TILBURY2

TRO30003

ERRATA EXPLANATION TABLE

DOCUMENT REFERENCE: PoTLL/T2/EX/4

Title:
 Port of Tilbury (Expansion) Order 2017
 Crown Land Plan - Regulation 5(2)(n)
 Sheet 6

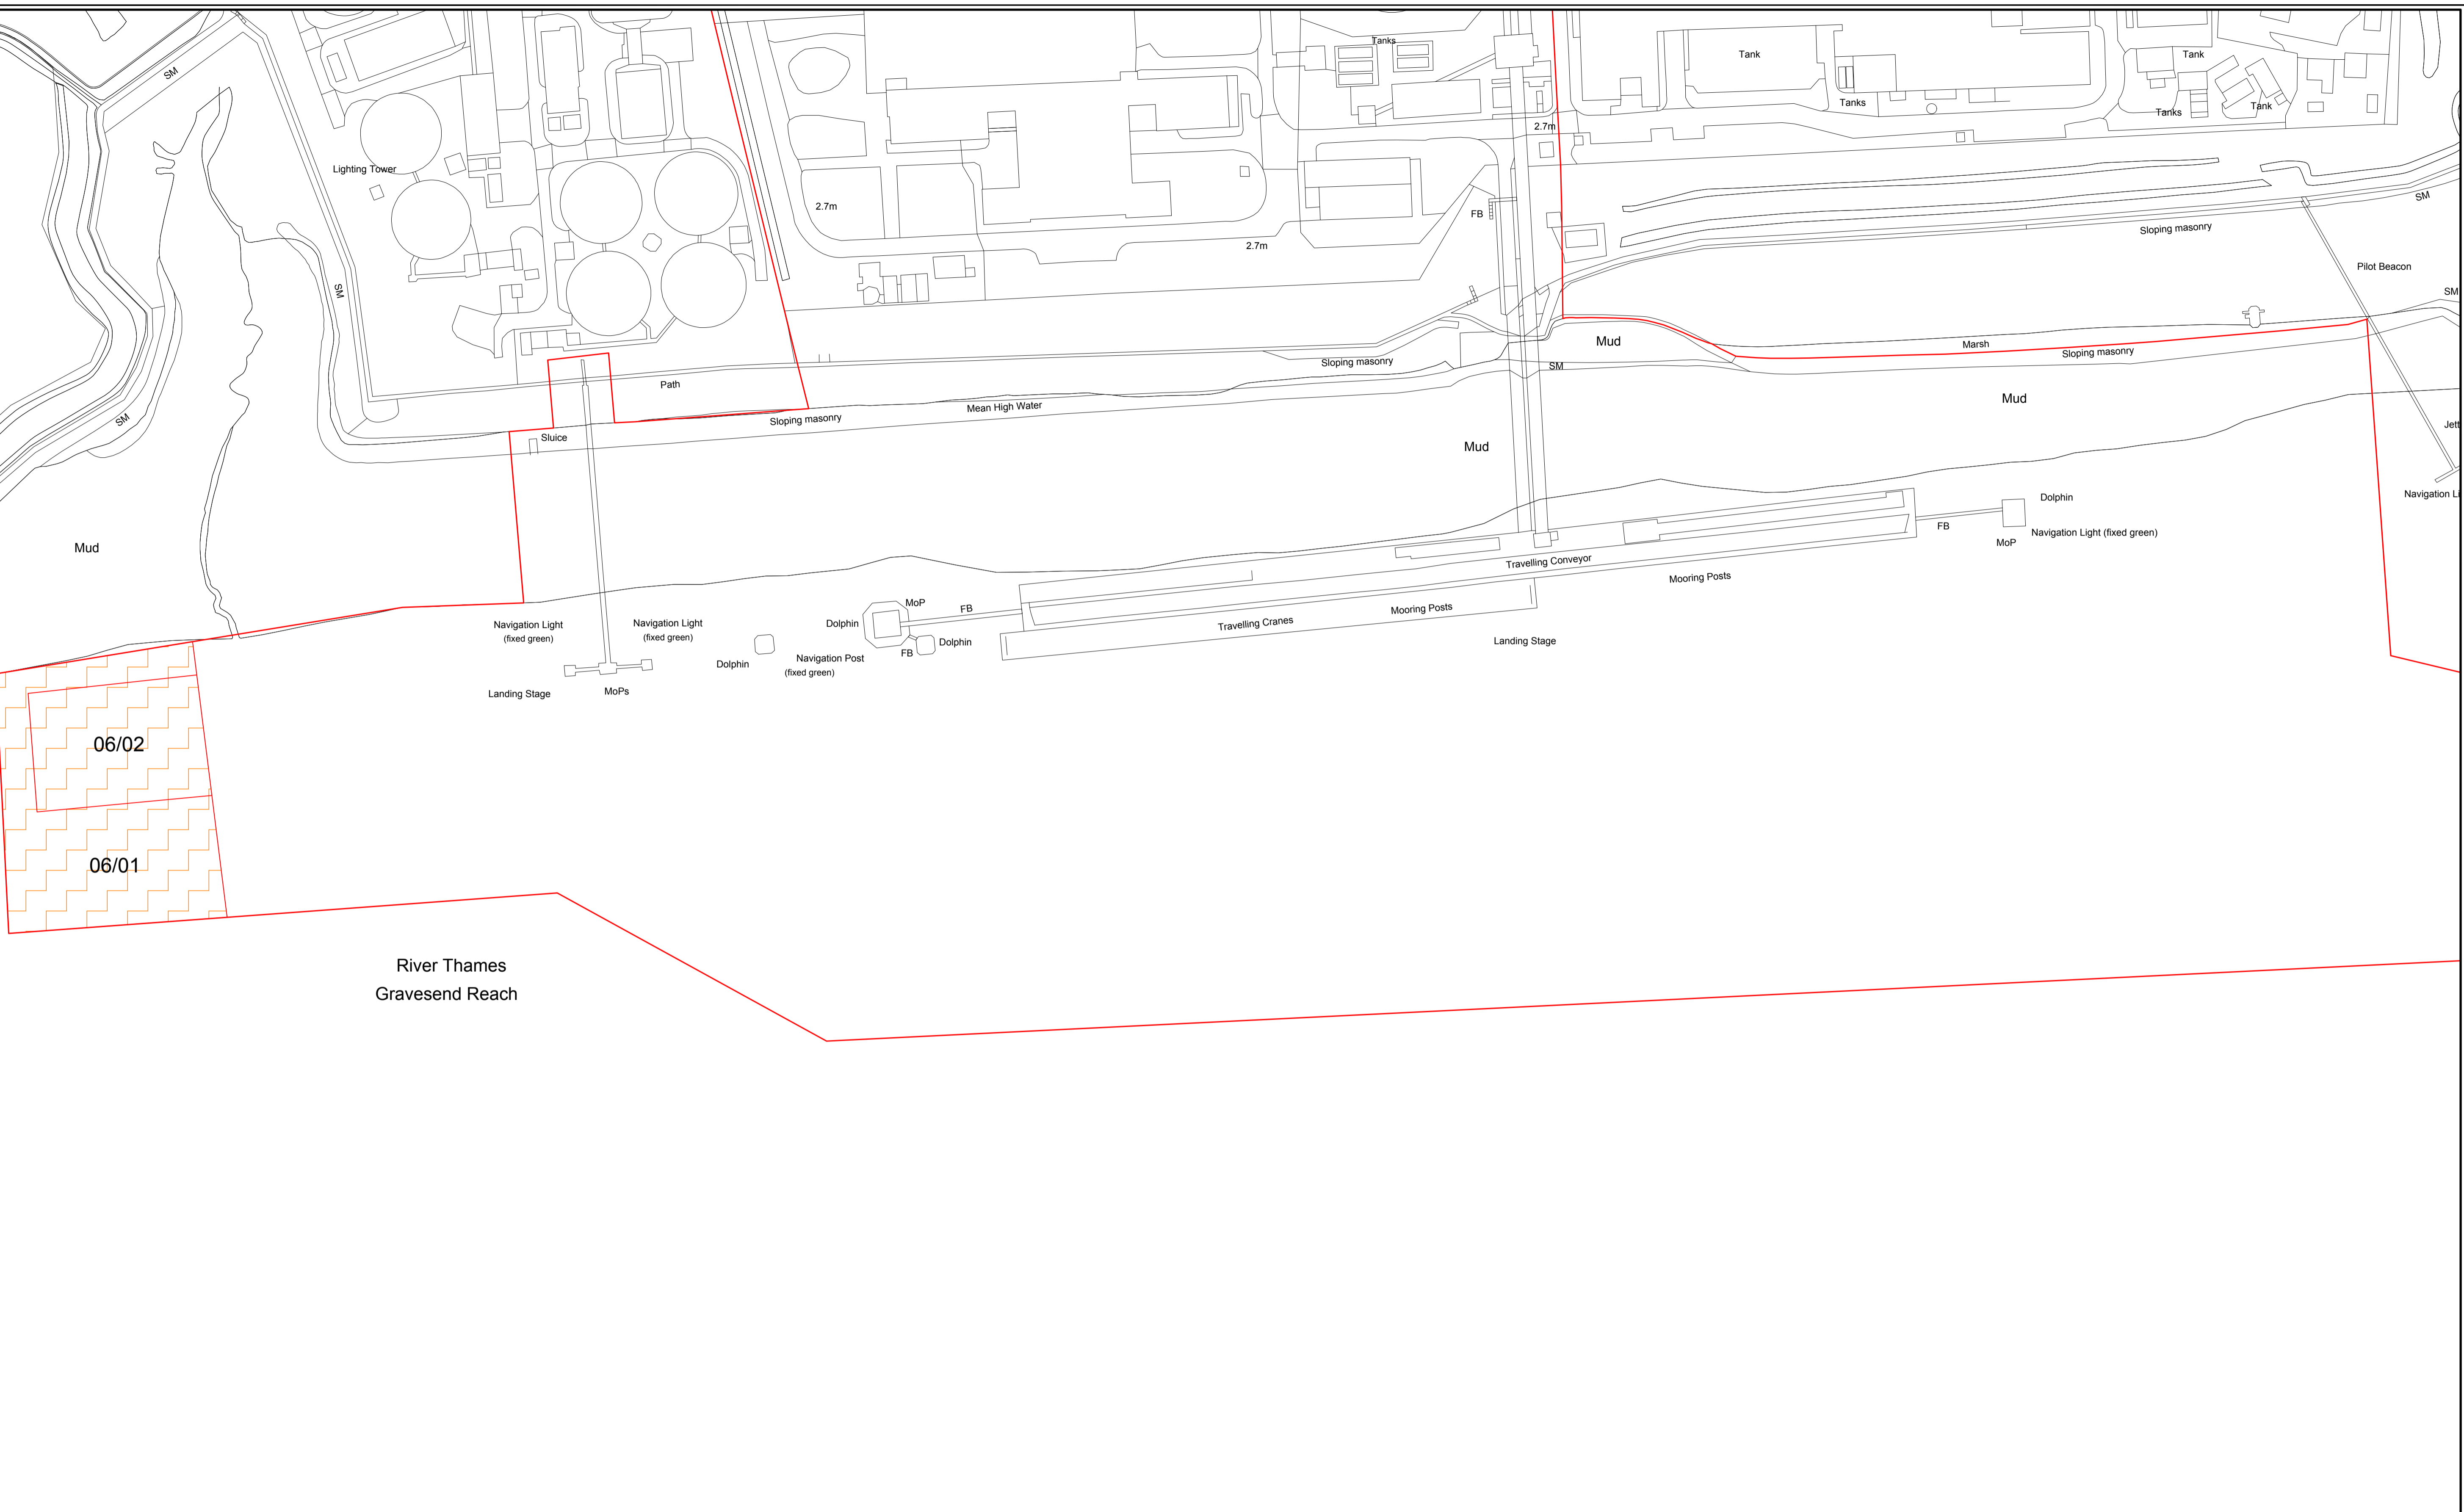
Application Document Reference	Application Document Title	Nature of Erratum	Explanation/Revised Text	New Document Reference
2.1	Land Plan, Crown Land Plan and Special Category Land Plans	Colouring Change of land requirements for Crown Land	<p>Within the Planning Inspectorate's (PINS) Acceptance section 51 advice (section 51 advice), there is a comment that the colouring on these plans was potentially too 'light'. This set of plans is therefore being re-provided in full with darker colouring to enable the plans to be more easily read.</p> <p>This updated set also reflects the latest stage of discussions with the Crown Estate in relation to the Crown land that is affected by the proposals. This change involves plot 06/02, which was shown as being required for full compulsory acquisition of land (subject to the restrictions in section 135 of the Planning Act 2008) in the application version of these plans. It has now been agreed that this plot should be shown as compulsory acquisition of rights, in order to then inform negotiations in respect of the required Crown land consent. This is therefore reflected by the yellow tint now shown for this plot in this errata set of plans</p>	PoTLL/T2/EX/5

ENVIRONMENTAL STATEMENT APPENDIX 16C WATER FRAMEWORK DIRECTIVE ASSESSMENT - CULVERT LOCATION PLAN

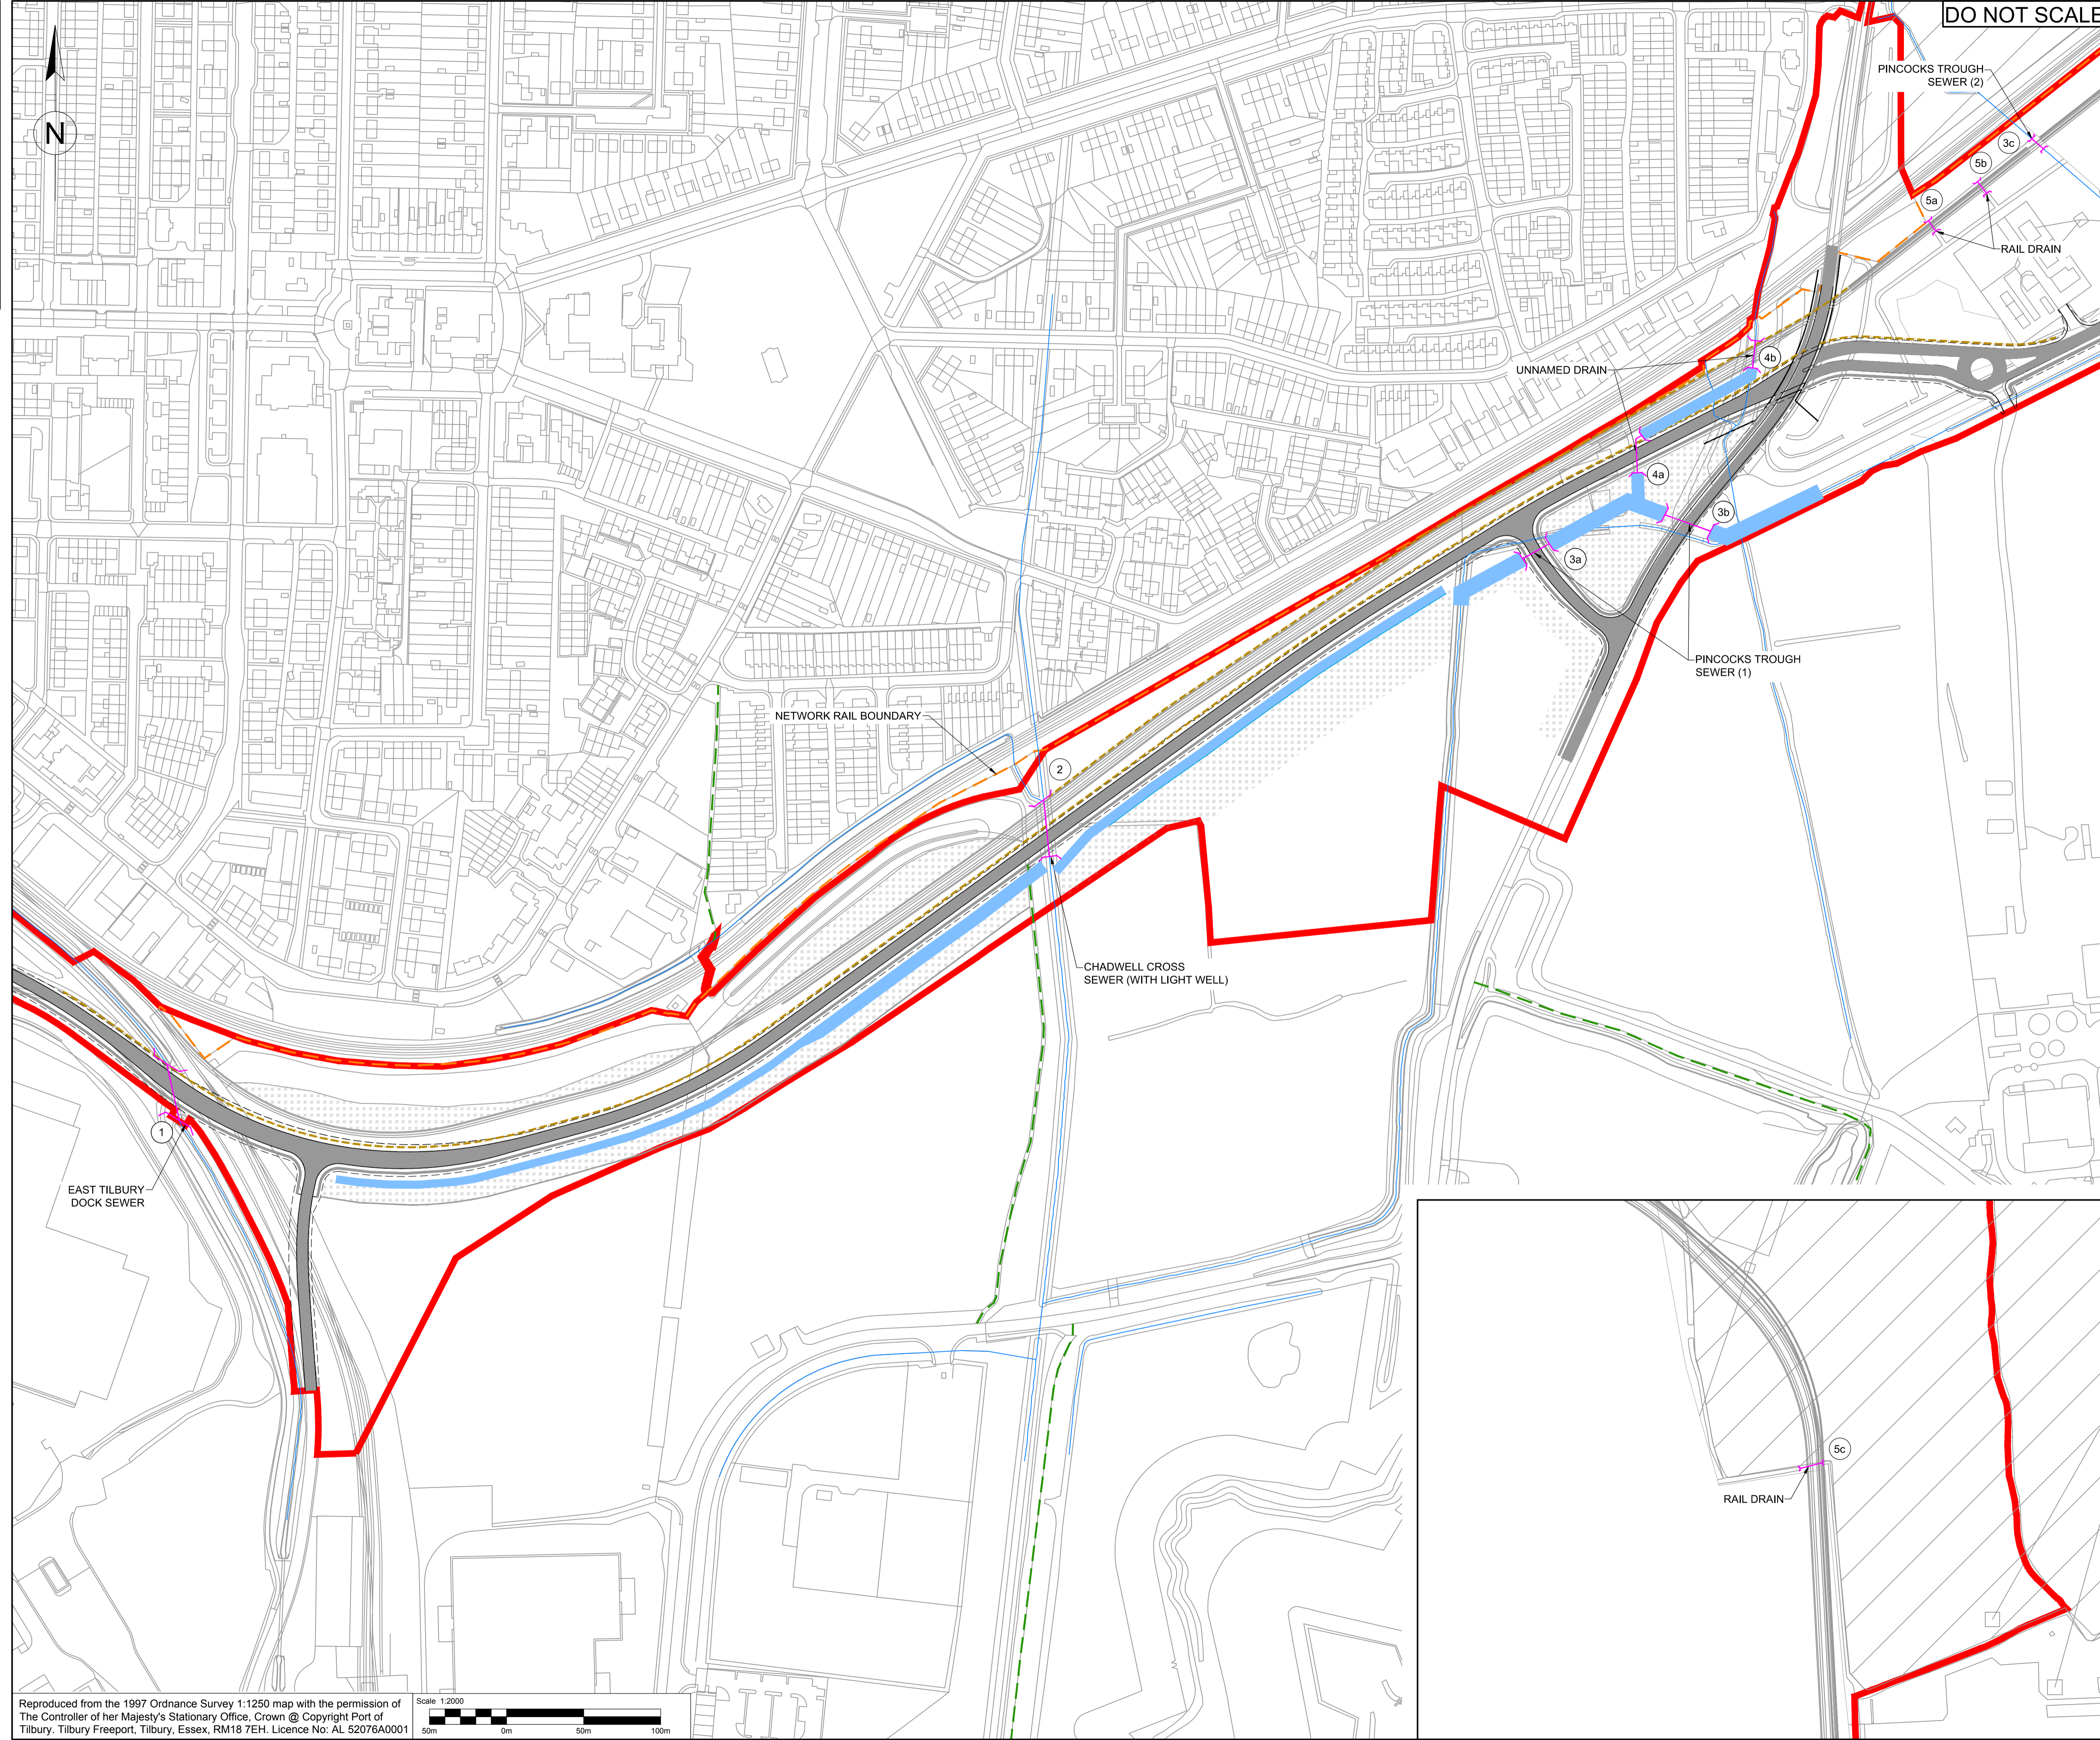
6.2.16C	ES Appendix 16C: Water Framework Directive Assessment	Missing plan	Paragraph 1.269 of this document refers to a Culvert Location Plan as document number 5153187/ATK/ZZ/XX/DR/IF/1015. This plan should have been included within this WFD assessment and was not included in error. This errata submission therefore comprises the omitted Culvert Location Plan.							PoTLL/T2/EX/19
